# Rezoning Transportation Analysis

Petition Number: 2022-119

Date	Description
12-29-22	First Review (TM)

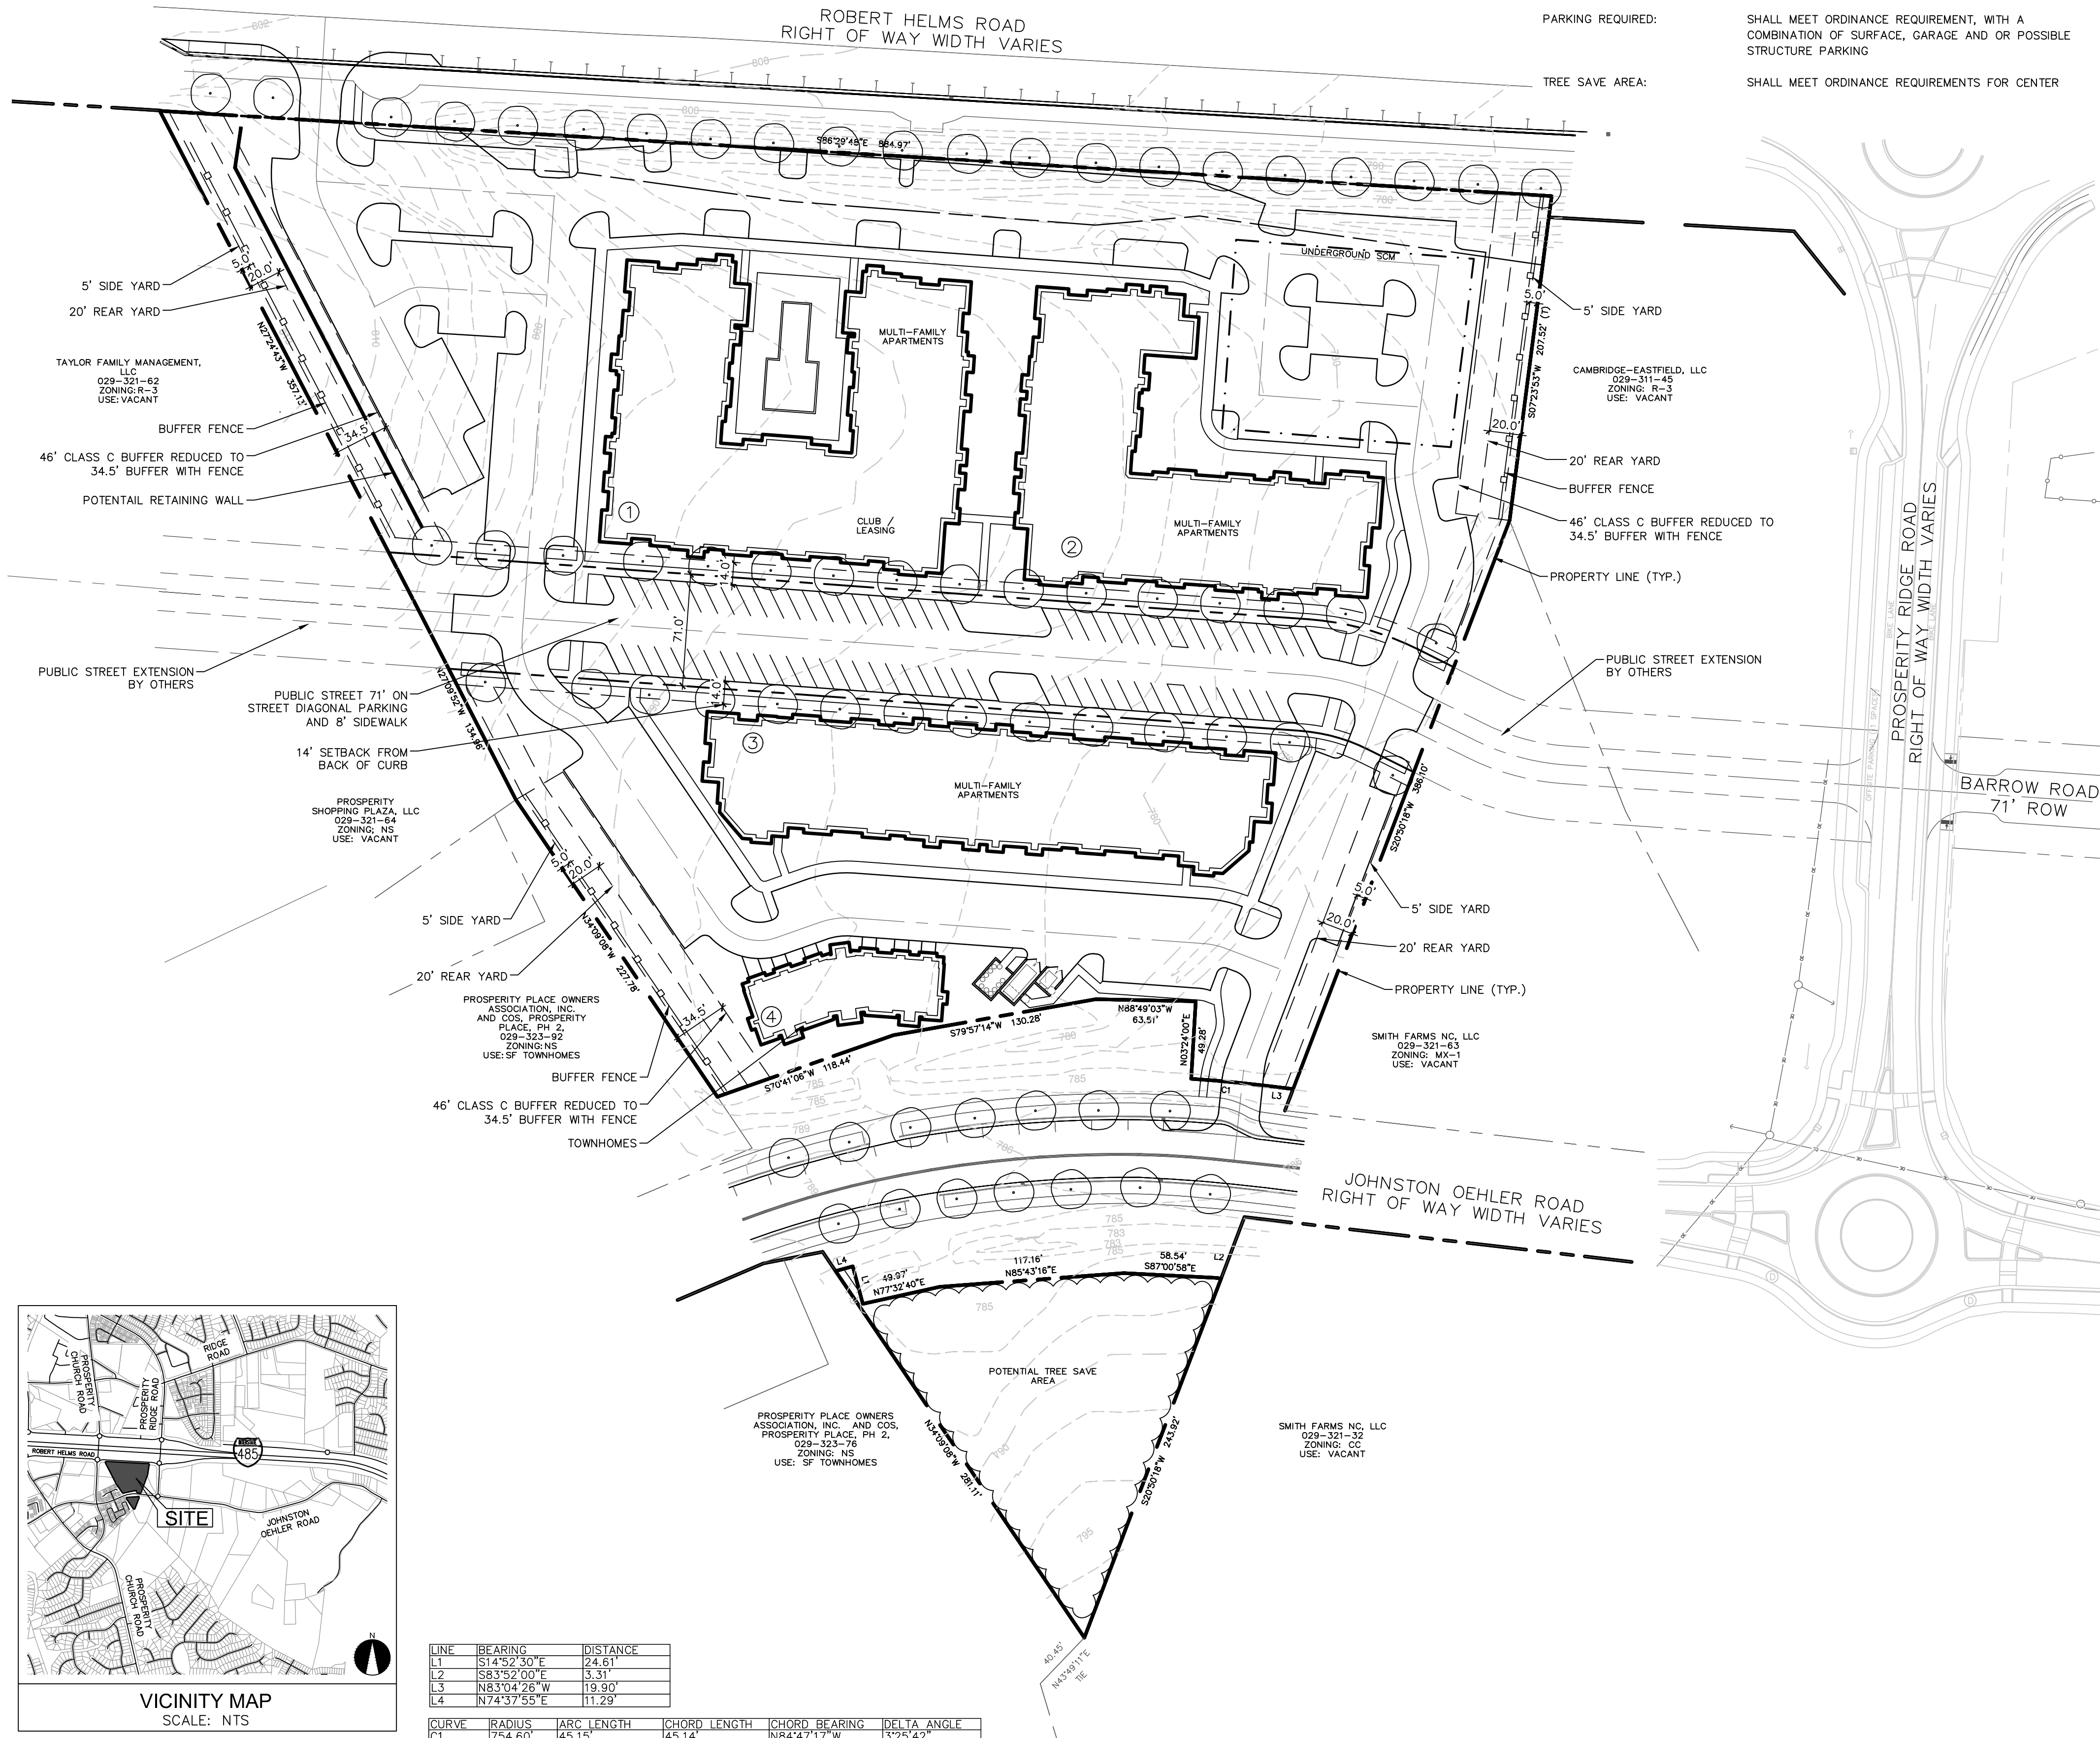
Label and dimension the curb and gutter from the centerline for each road on the site plan.

- Revise site plan by dimensioning and labeling all ROW along Robert Helms Road and Johnston Oehler Road from the roadway centerline.
- Revise site plan and conditional note(s) to commit to construct an 8-foot planting strip, and 8-foot sidewalk on the internal public roadway extension per Chapter 19. The site plan shall label and dimension both items from the back of curb and gutter or edge of pavement.
- The proposed dwelling units exceeds 12 per acre. Per Chapter 20 Subdivision ordinance, revise site plan and conditional note(s) to commit to construct an 8-foot planting strip, and 8-foot sidewalk along the public roadway extension. The wider sidewalk also meets the Charlotte WALKS Policy.

8. Revise site plan and conditional note(s) to commit to existing on-street parking by adding an ADA stall to Johnston Oehler Road and Robert Helms Road.

9. Revise site plan and conditional note(s) to remove the site entrance on Robert Helms Road per NCDOT comments.
10. Revise site plan and conditional note(s) to extend all public infrastructure along the public roadway extension to the property line.

11. Revise site plan and conditional note(s) to callout the roadway extension roadway cross section per CLDSM.
12. Revise site plan and conditional note(s) by revising on-street parking space along the proposed public roadway extension to be installed as parallel parking stalls. One stall shall be an ADA compliant stall.

13. Revise site plan and conditional note(s) by adding a conditional note and callout to the site plan committing to coordination with CIP project Craven Thomas Road/Robert Helms Road Streetscape (Prosperity Village CNIP).
